CITY OF ALBUQUERQUE

**RE: Lot 24 Rancho Guadalupe
1616 Rancho Guadalupe Trail
Request for Permanent C.O. - Accepted
Engineers Stamp Date 11/21/14 (F13D002C)
Certification Dated: 8-13-15**

**Re: Lot 24 Rancho Guadalupe Subdivision
Grading and Drainage Plan
Engineer's Date 11-21-14 (F13D002C)**

**Re: Lot 24 Rancho Guadalupe Subdivision
Grading and Drainage Plan
Engineer's Date 10-16-14 (F13D002C)**

GRADING AND DRAINAGE PLAN

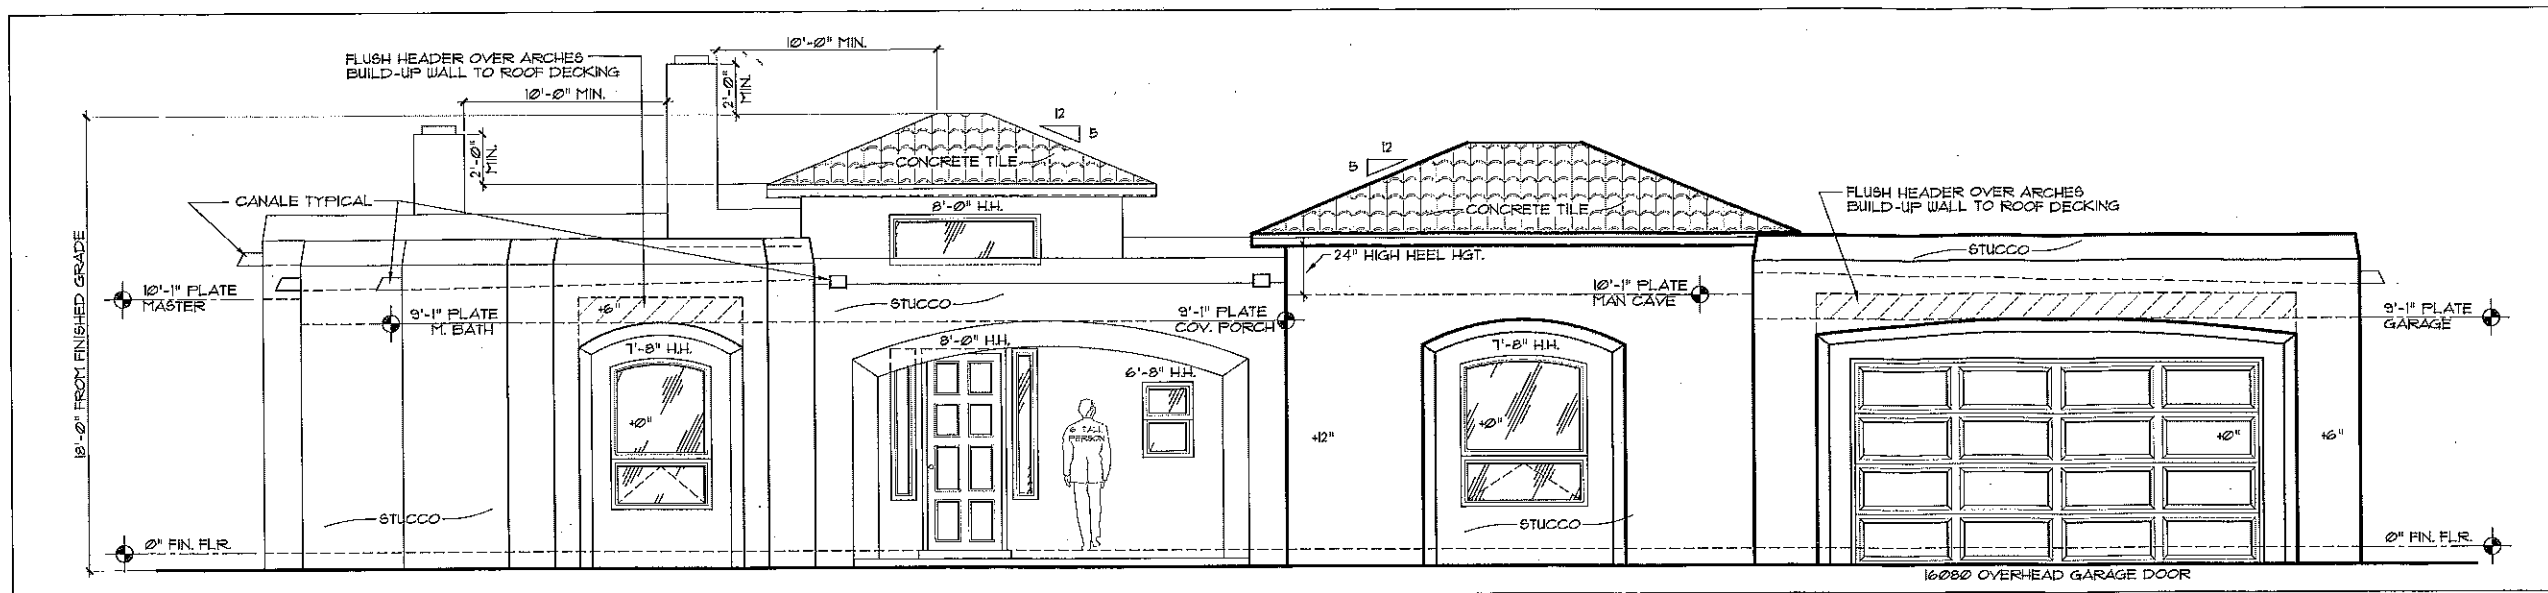
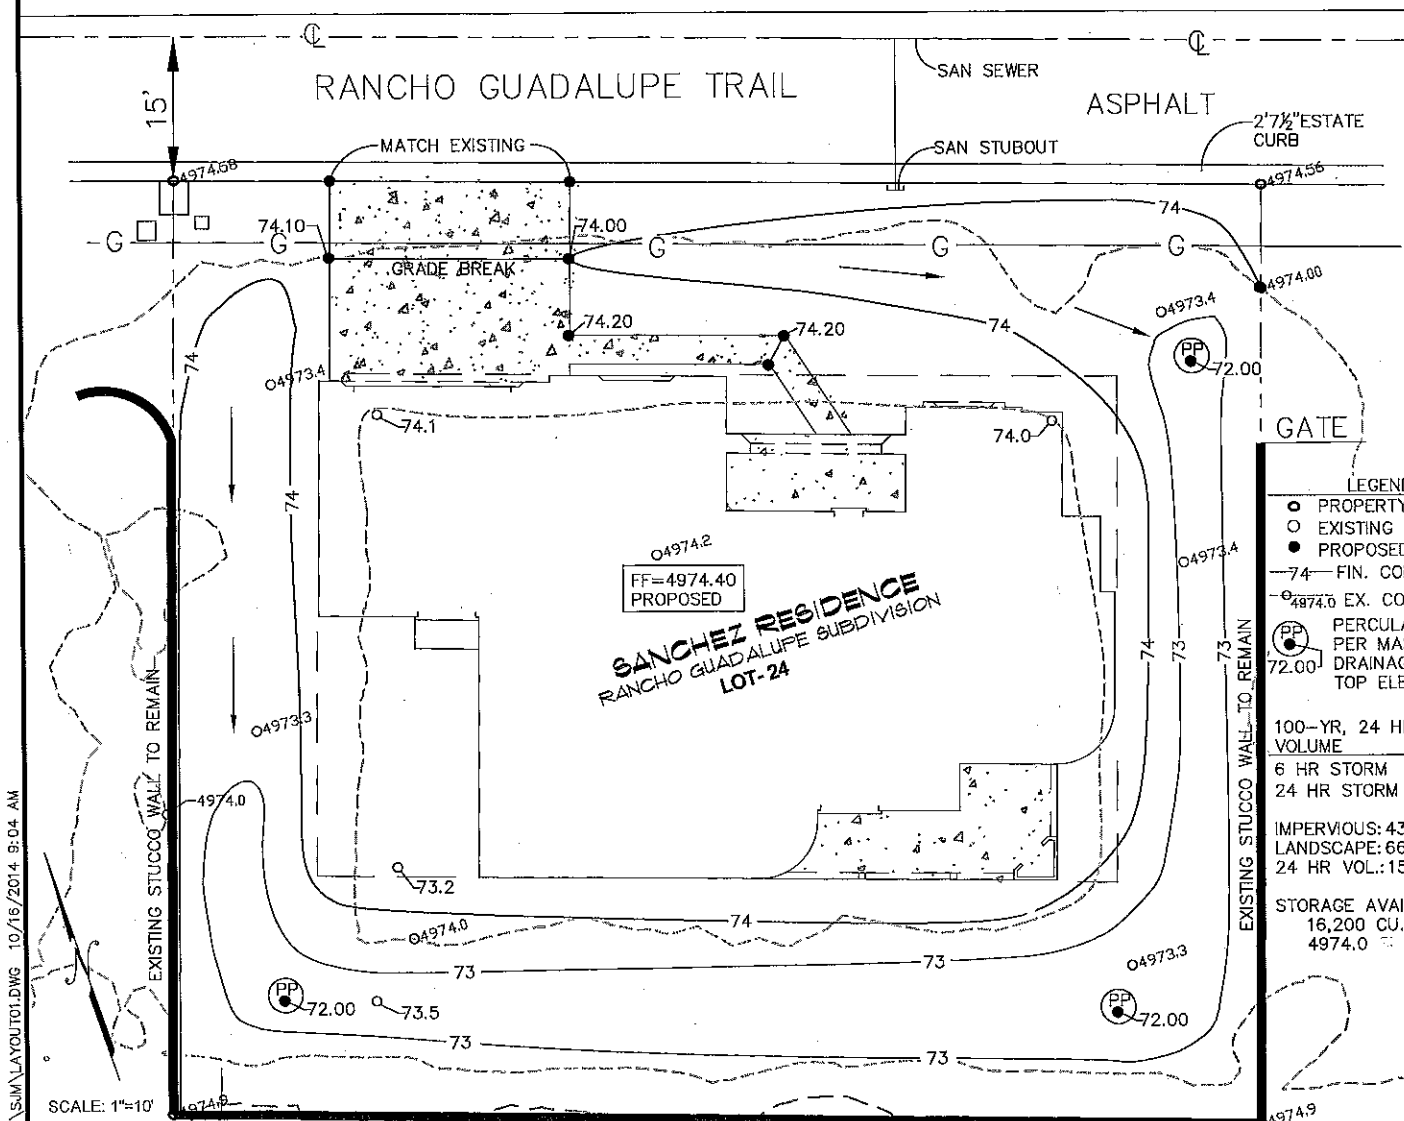
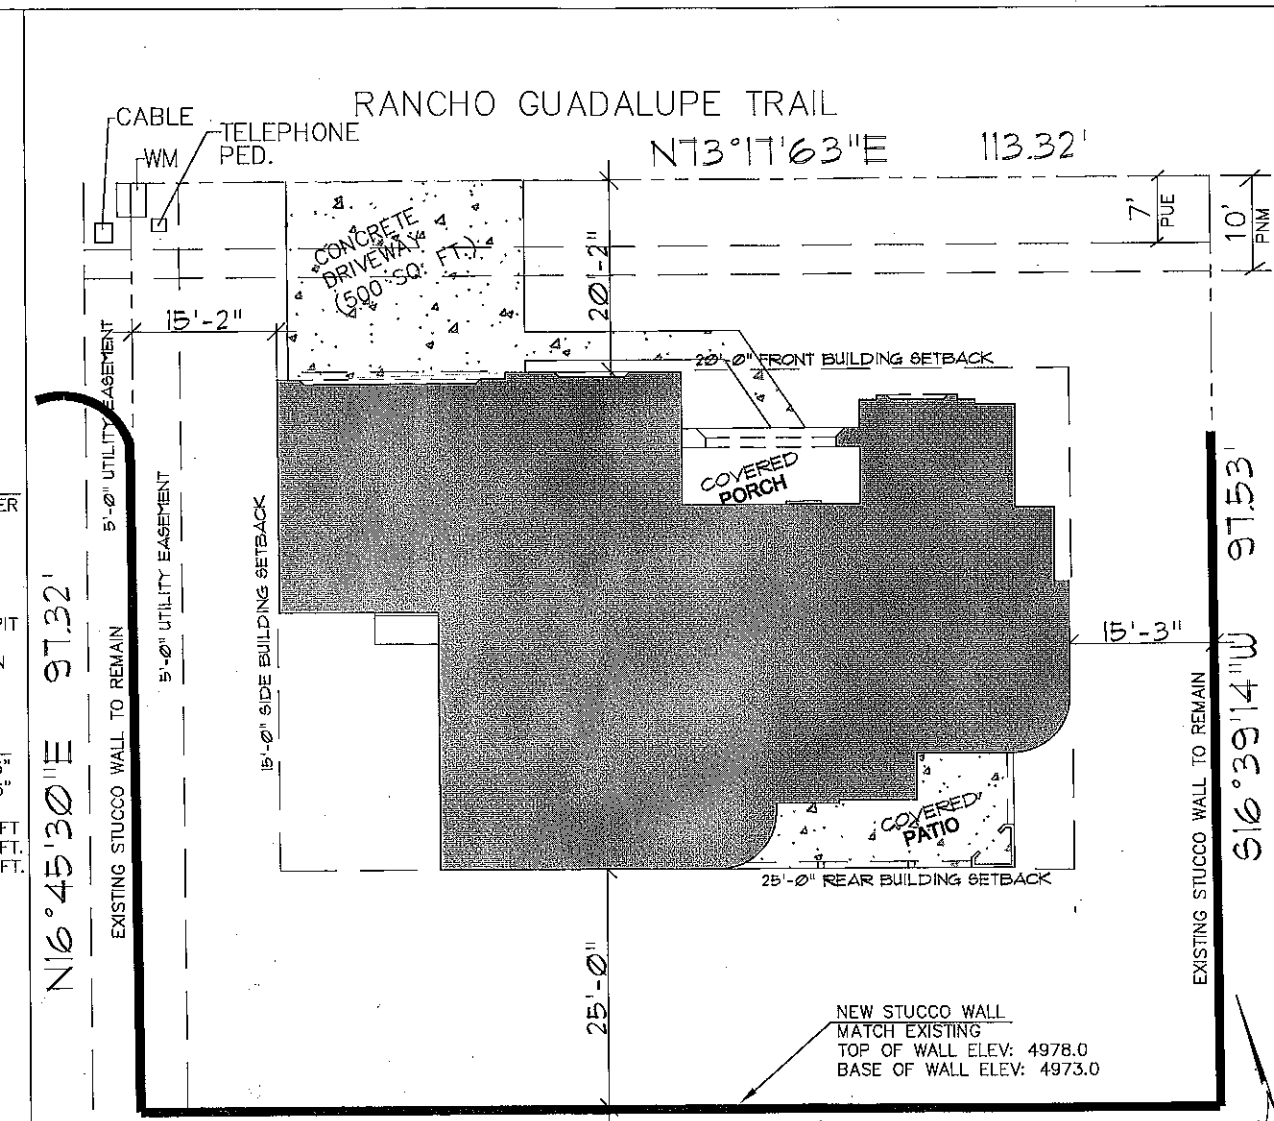
Based upon the information provided in your submittal received 11-3-14, the above referenced plan is not approved for Building Permit. Please address the following comments:

1. Provide a percolation pit detail that is per the master drainage plan. The pit should release to the sand strata.
2. The First Flush was not discussed. Per the City Drainage ordinance, the 90th Percentile Storm Event, which is 44 inches, is to be managed. Reduce 0.44 inch by the 0.1 inch for the initial impervious abstraction in Table A-6 of Section 22 of the DPM. Multiply the remaining 0.34 inch by your impervious area. This is the amount of the First Flush necessary for the site. Show that amount on your plans. State that the capacity provided by the proposed ponding is greater than what is required for the First Flush.
3. The 74 contour is not addressed in the back. Is the back wall acting as a retaining wall or is there simply a steep grade?
4. Provide a discussion of the 100 Year Flood Plain.
5. Include a site map with the site identified.
